Midtown Stage 2 Response to SDRP Extended Session #2 – 17th June 2021	
SDRP feedback	Teloopa design team response
Connecting with Country	
<p>1. The approach to connecting with Country and resulting emerging initiatives are supported, including:</p> <ul style="list-style-type: none"> • working with The Fulcrum Agency to guide engagement with the local Aboriginal community, to achieve both short and long-term goals • development of a corporate approach to connecting with Country • the aspiration of a community bush-tucker garden on the C2 pool roof – it is recommended the garden be developed in collaboration with local Aboriginal knowledge holders. 	<p>Noted. As advised in the SDRP session#2, correct and early stakeholder consultation and engagement is the key to truly connecting with country in a meaningful way. This very important as engagement can take many months to correctly undertake.</p> <p>Frasers have procured a Connecting with Country strategy document with a range of recommendations that we are now reviewing and implementing. This report has been included in the Development Application to allow the process to be conditioned in the consent.</p> <p>Our intention is to now s

1 Level 05 - Forest Room 1
Scale: 1:50

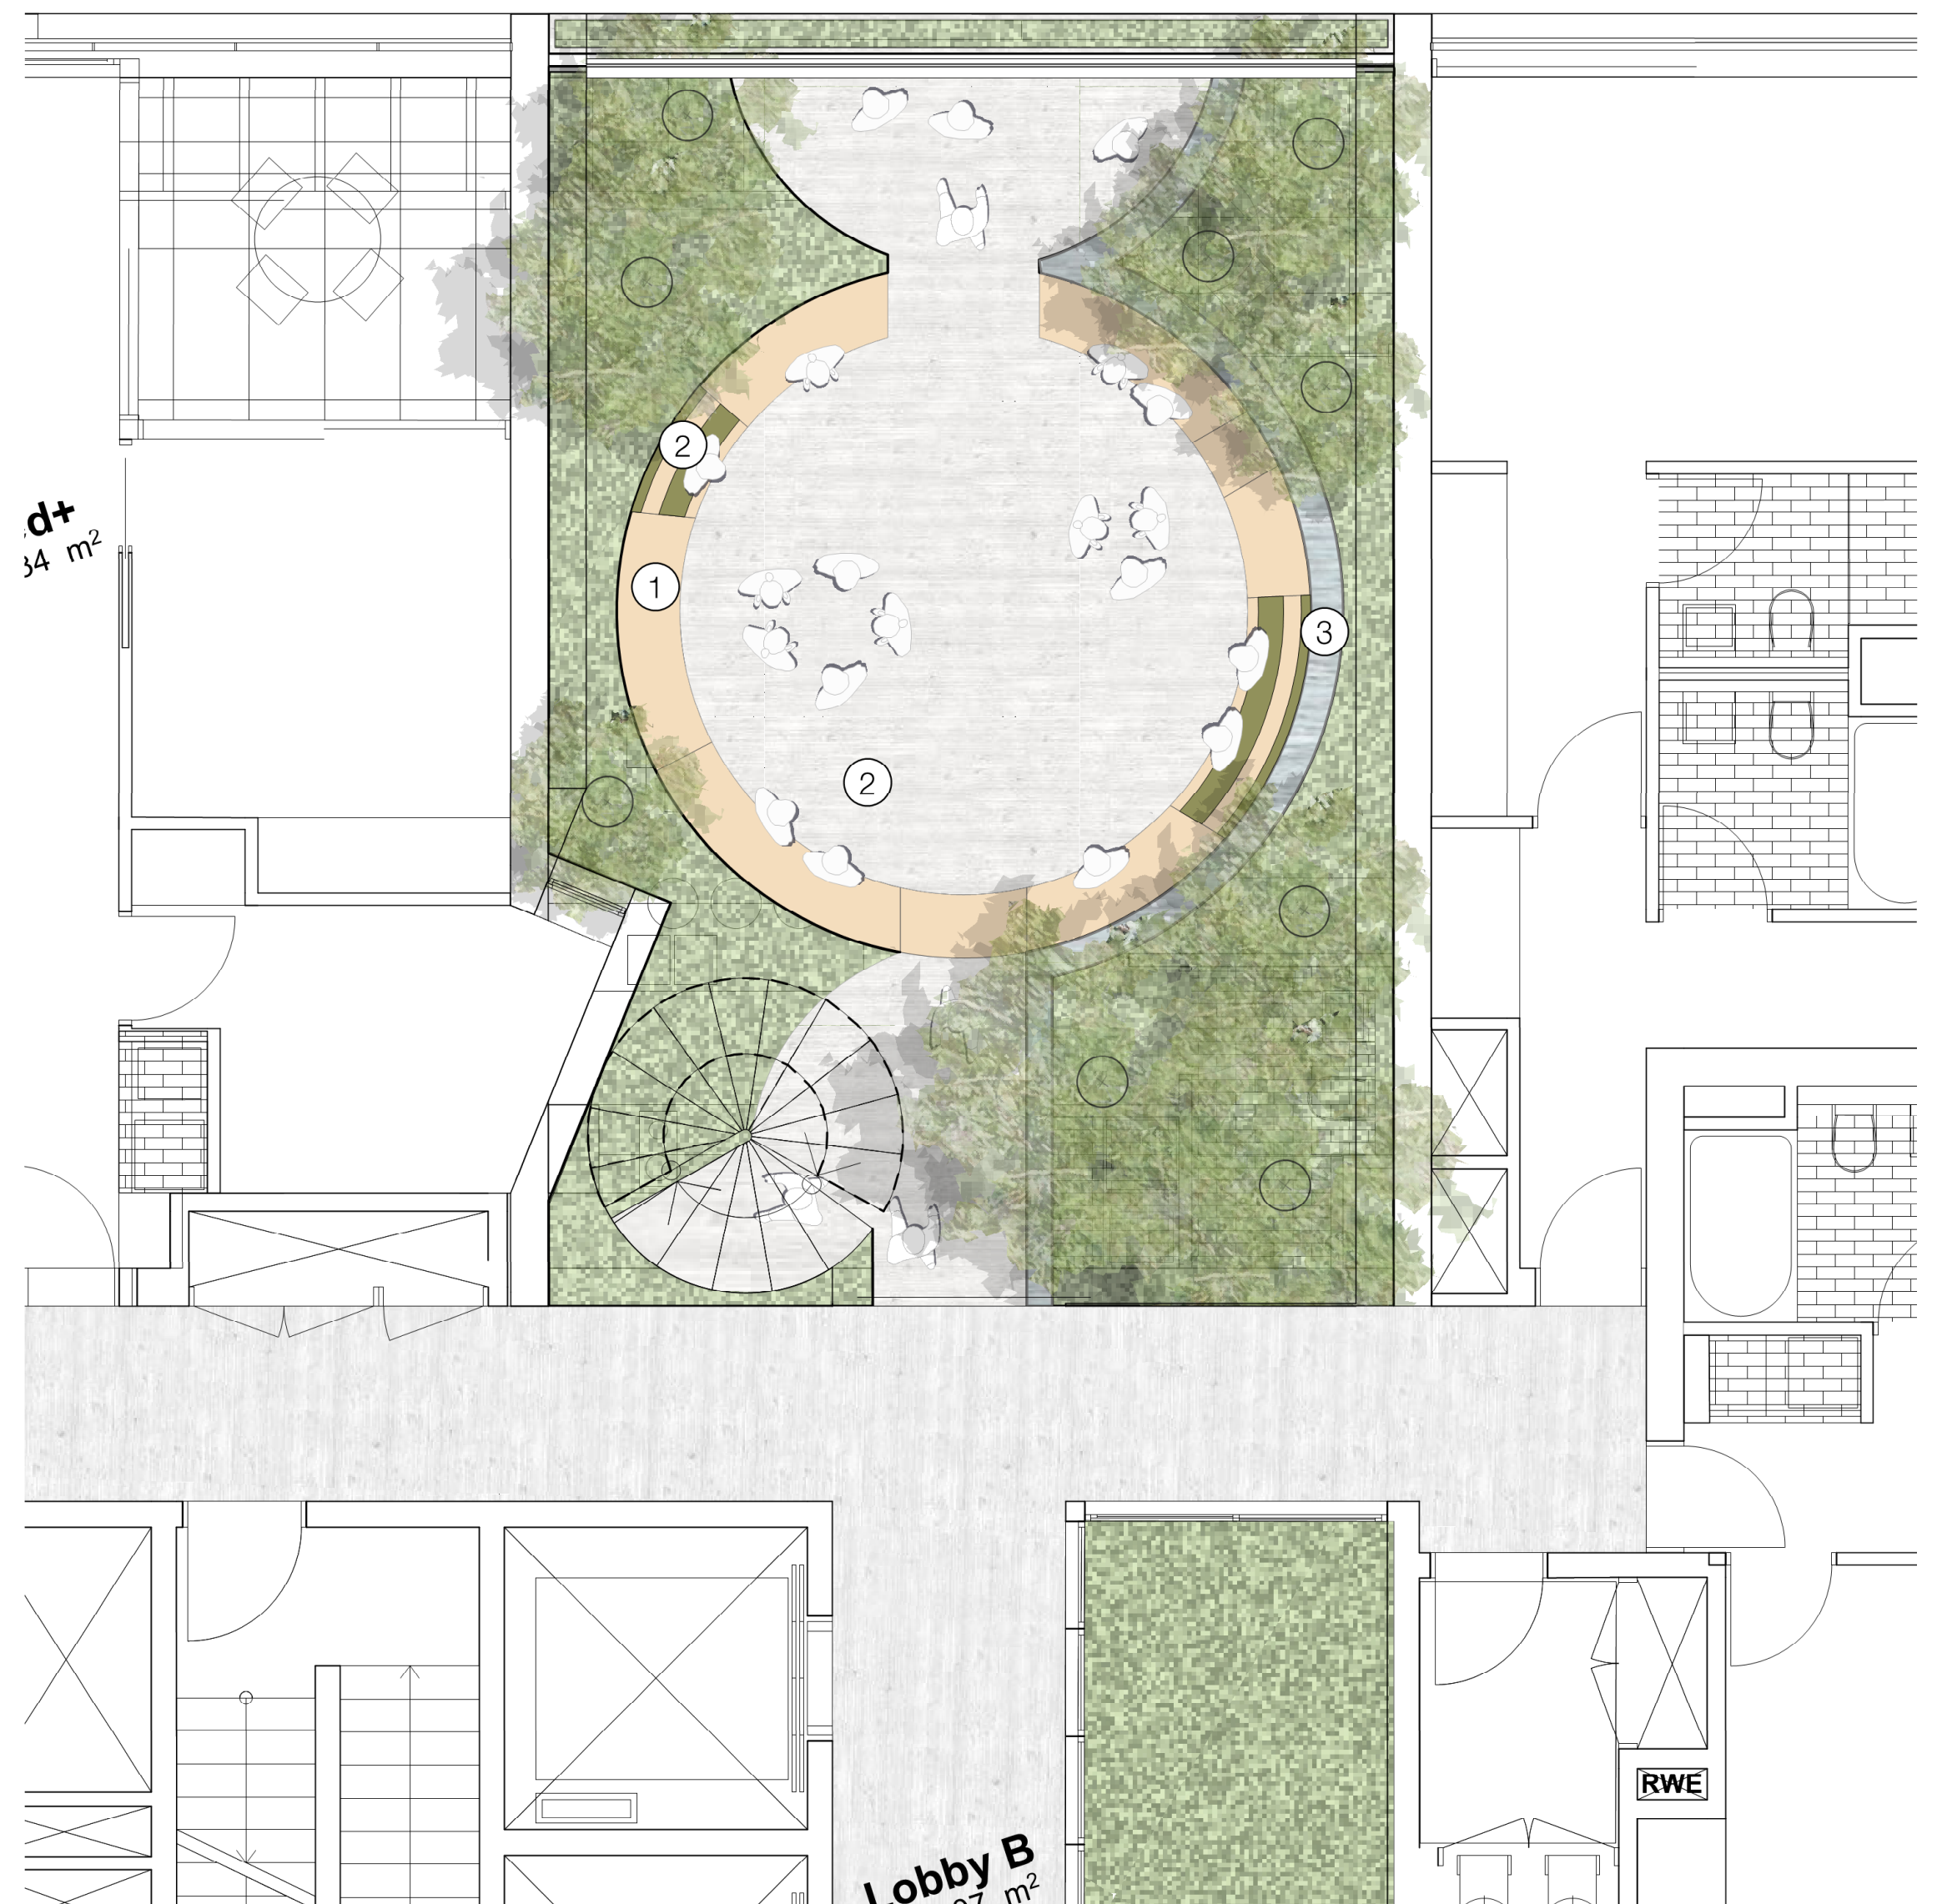
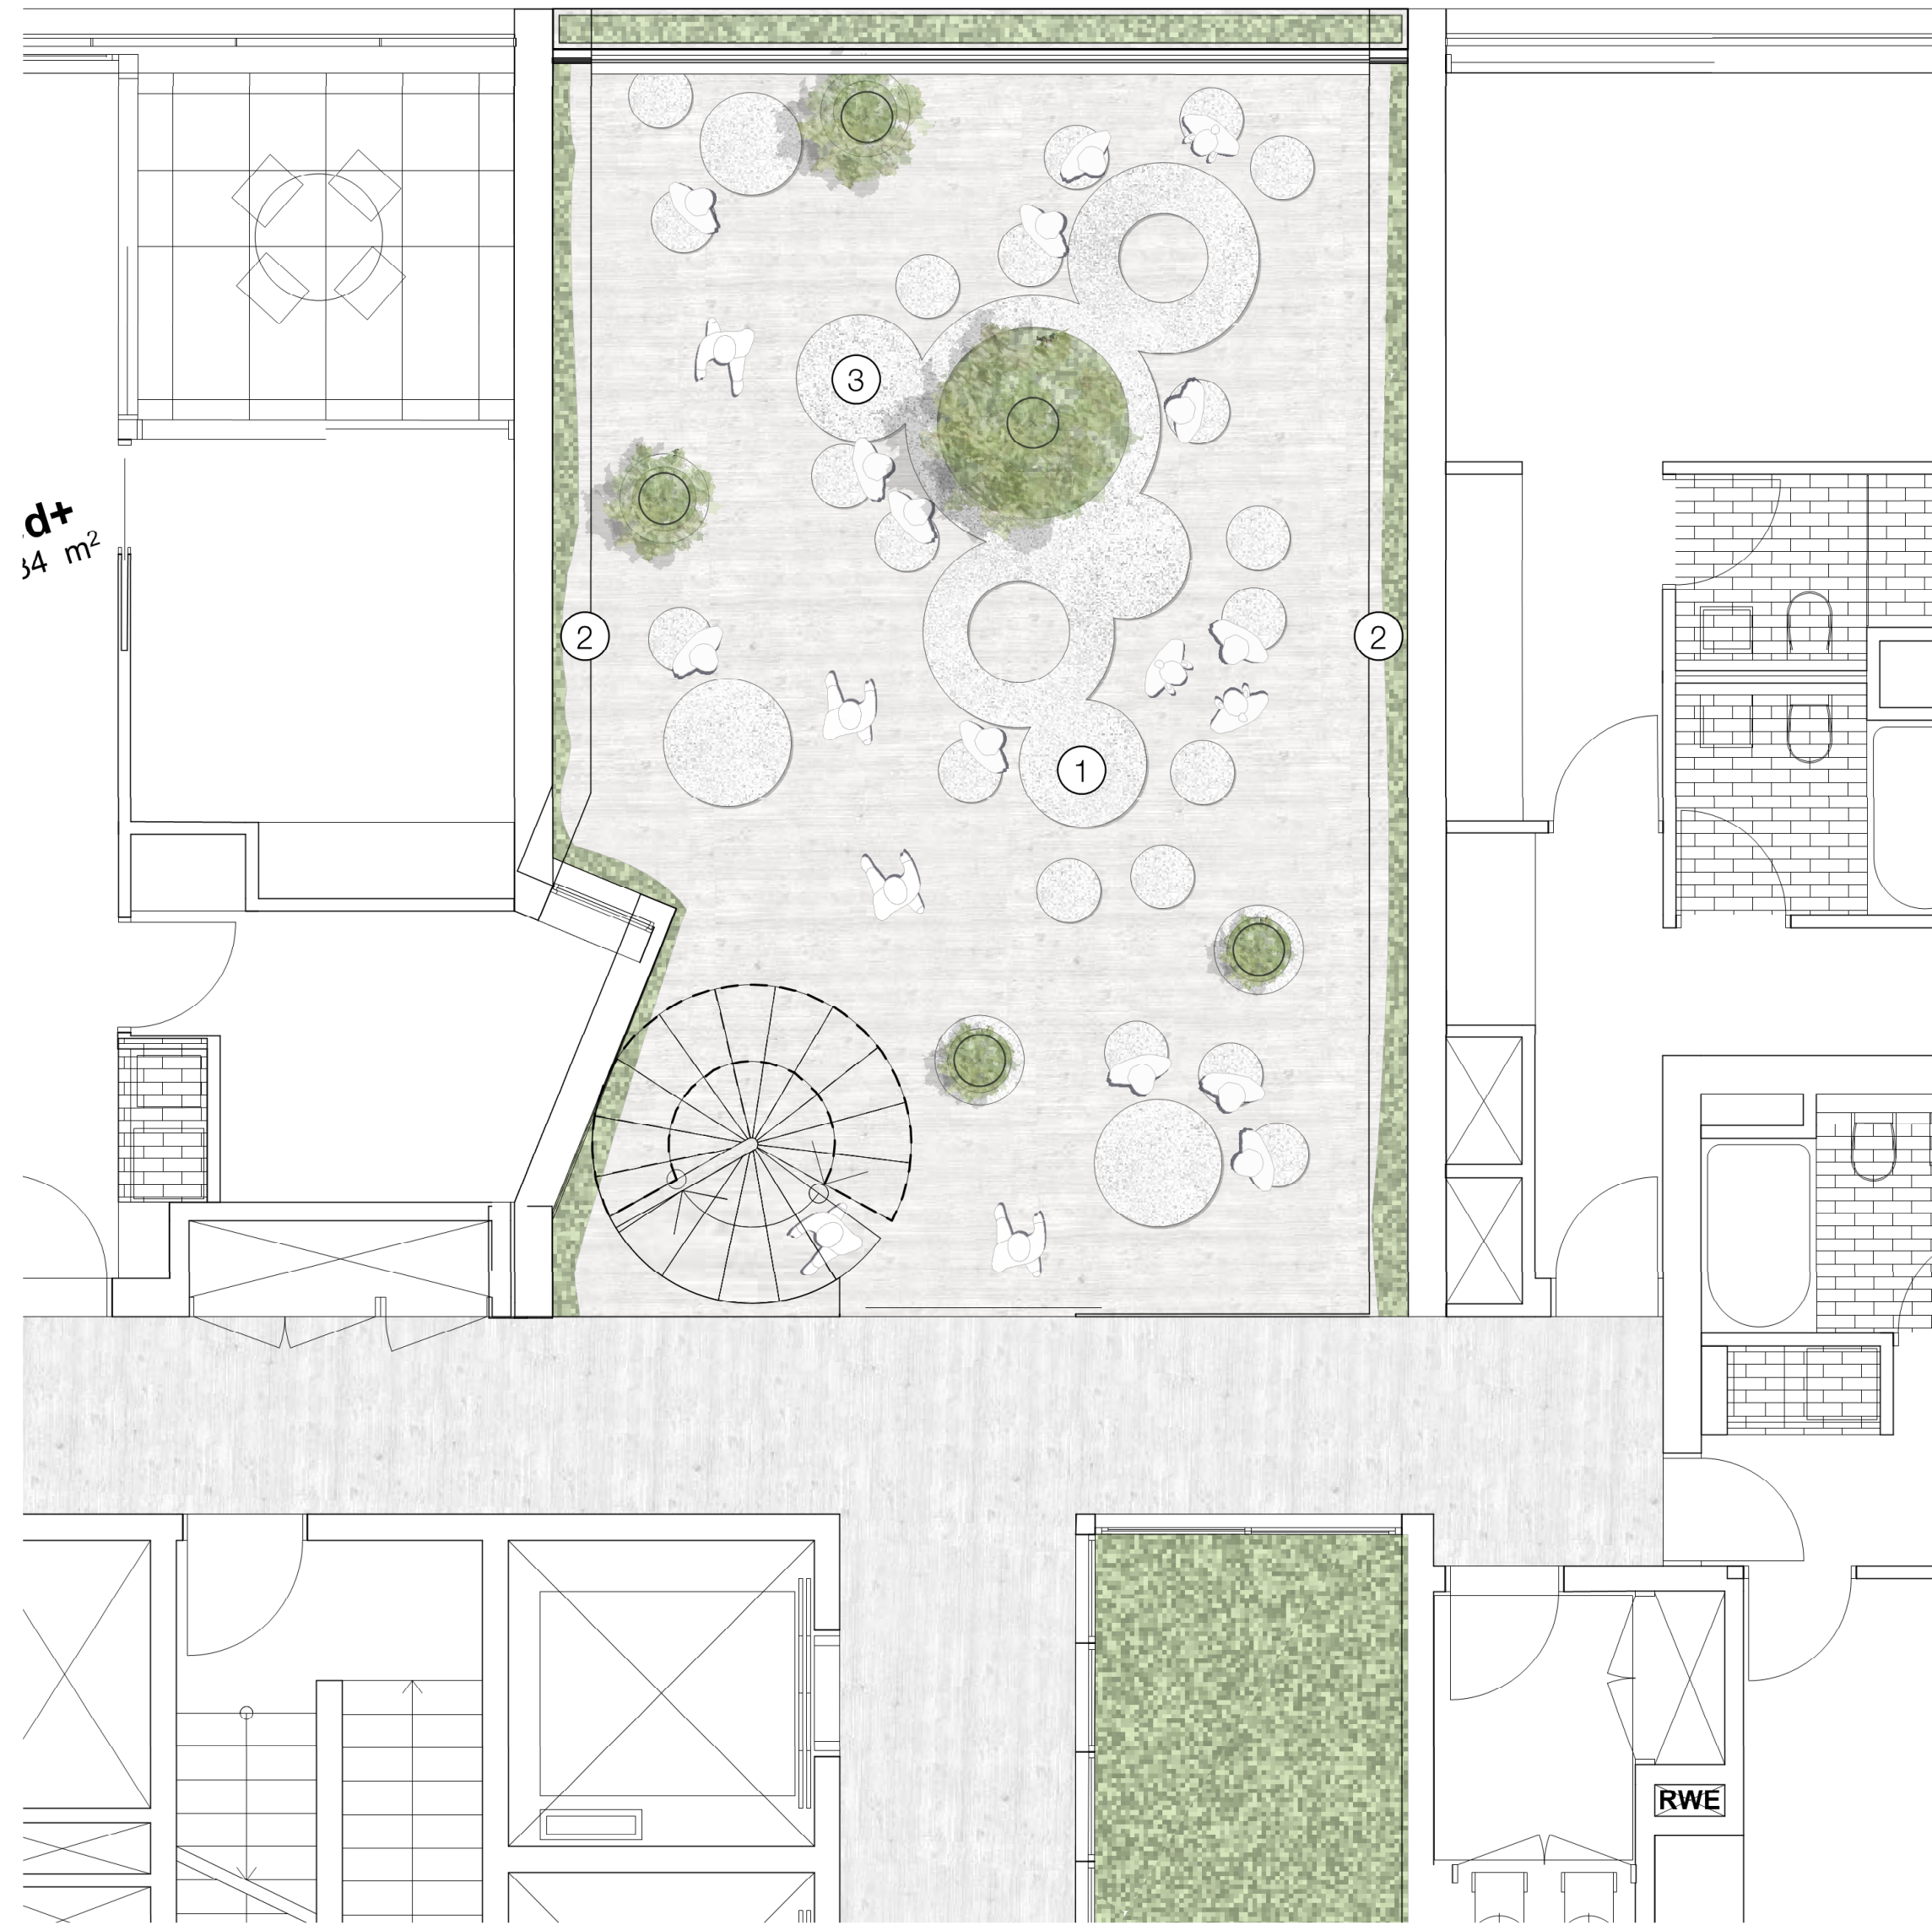
<p>12. The following responses to SDRP 01 are supported:</p> <ul style="list-style-type: none"> • detail of the three-storey communal '<i>forest gardens</i>' including vertical connections between levels • the architectural expression of the façade's central recess element • relocation of all residential ground floor entrances to Neighbourhood Street – Road 3 • sun-shading to typical apartments. 	Noted.
<p>13. The ground floor links to the Village Green have been removed but remain the preferred design outcome, offering benefits of connectivity and inclusiveness for the precinct – reinstatement is strongly recommended. Constraints of wind and service planning are noted.</p>	<p>The C3 design team looked at this option extensively. Providing through site links within the ground plane of C3 had multiple compromises that were negatively affecting the overall development and public domain. The benefits of this link were seen as minimal.</p> <p>The specific concerns with including a link were;</p> <ul style="list-style-type: none"> - Creating a desirable pedestrian experience in what is essentially a tunnel; - CPTED concerns with the space; - Wind recommendations that required doors to ensure it was suitable for pedestrian walking; - The retail loading and BOH having to cross the pedestrian link to service the proposed supermarket from the loading dock; - A loss of prime north and park facing retail frontage; - The loss of true street address for the residential lobbies;
